Consultation Response from: KC Environmental Health (Pollution & Noise Control)
2022/92957 - Former Hoyle Ing Dyeworks, Hoyle Ing, Linthwaite, Huddersfield, HD7 5QS

Discharge conditions 3 (external facing materials). 4 (roofing materials). 5 (boundary treatment). 8 (demolition), 11 (BEMP), 13 (noise), 17 (Electric Vehicle Charging), 18 (Construction Management Plan), 19 (CEMP), 29 (waste collection) on previous permission 2021/94664 for demolition of existing building and development of the former Dyeworks comprising 9 apartments, 4 bungalows and 2 maisonettes (within a Conservation Area)

Responding Date:
08 November 2022

LAND OFF MANCHESTER ROAD, LINTHWAITE
PROPOSED EVCP PLAN

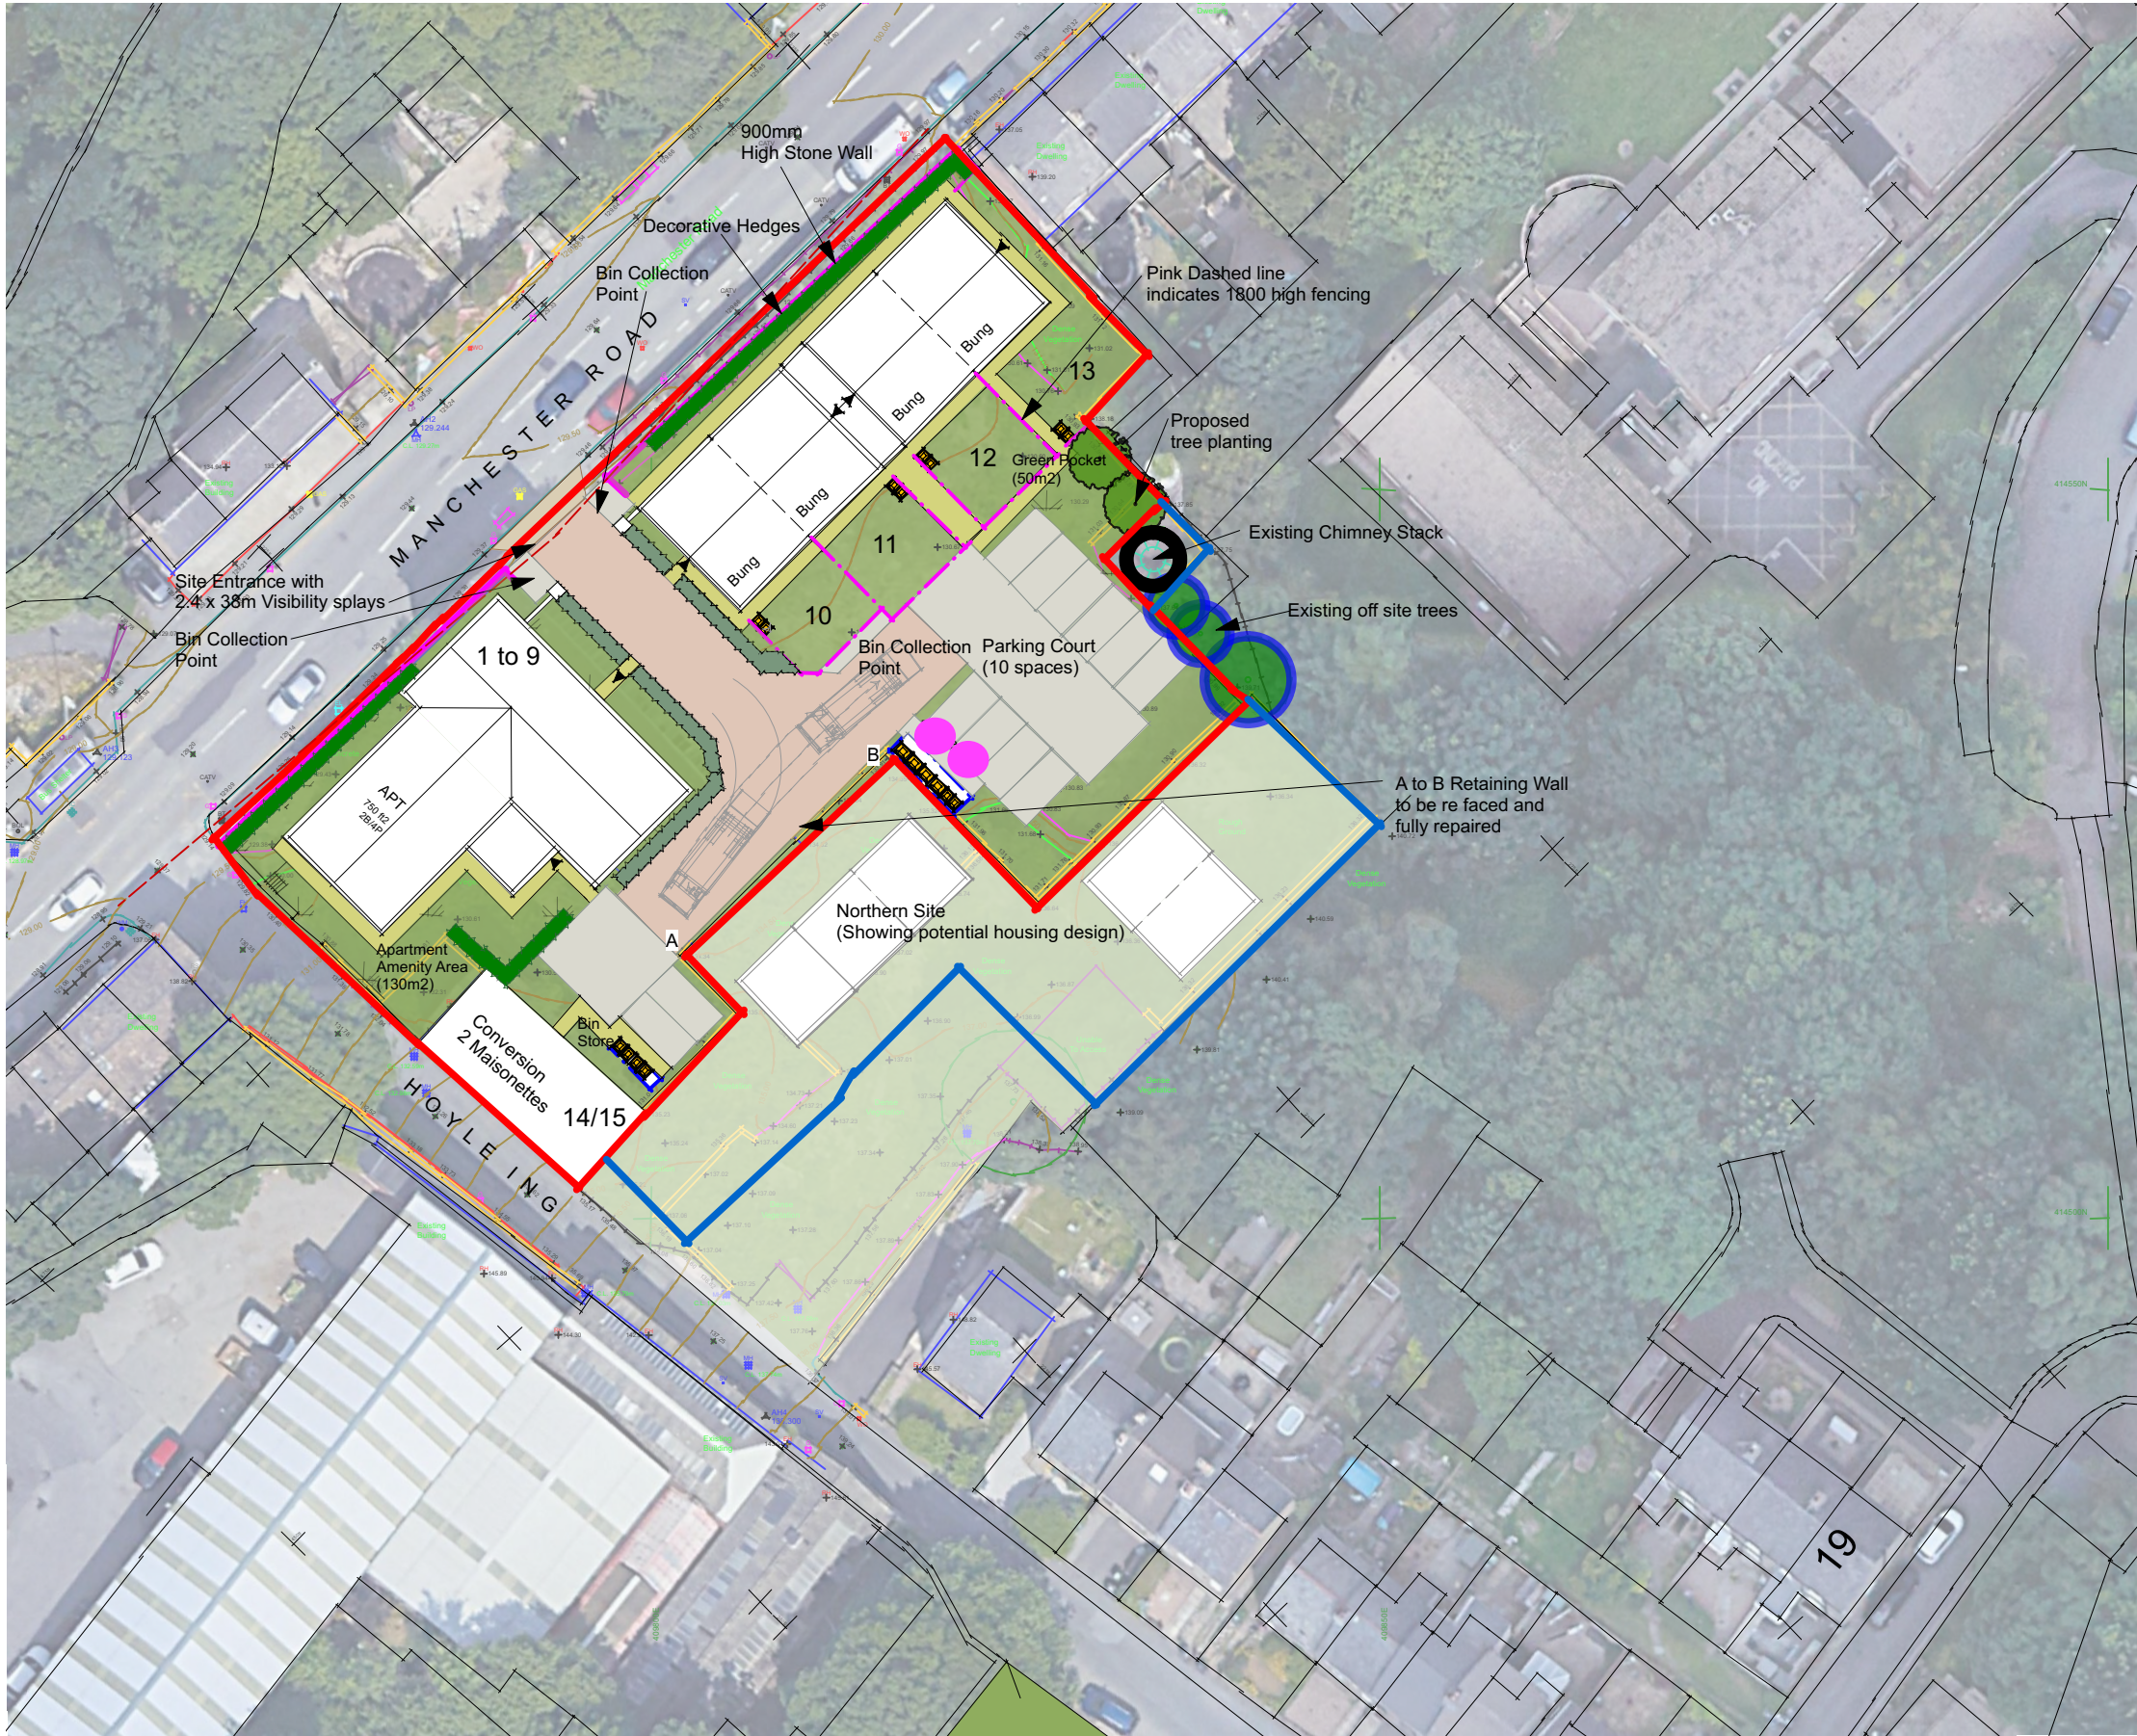
The applicant has submitted an un referenced and undated plan from Highstone showing the proposed EVCP locations. The plan indicates two '*Wallbox E Home Car charger, or similar specification on the market at the time of installation*' (as indicated by the pink markers). A Wallbox eHome data sheet has also been submitted which shows all models will meet with the requirements of the condition.

With regard to the allocation of parking spaces, the applicant is reminded of the requirements of the condition which states -

- A Standard Electric Vehicle Charging point providing a continuous supply of at least 16A (3.5kW) for each residential unit that has a dedicated parking space
- One Standard Electric Vehicle Charging Point providing a continuous supply of at least 16A (3.5kW) for at least 10% of residential parking spaces that are not allocated to specific dwellings

The allocation of parking and the associated number of EVCPs will need to be stated.

The submitted information does not meet with the requirements of the condition and therefore, we recommend the condition is not discharged at this time.
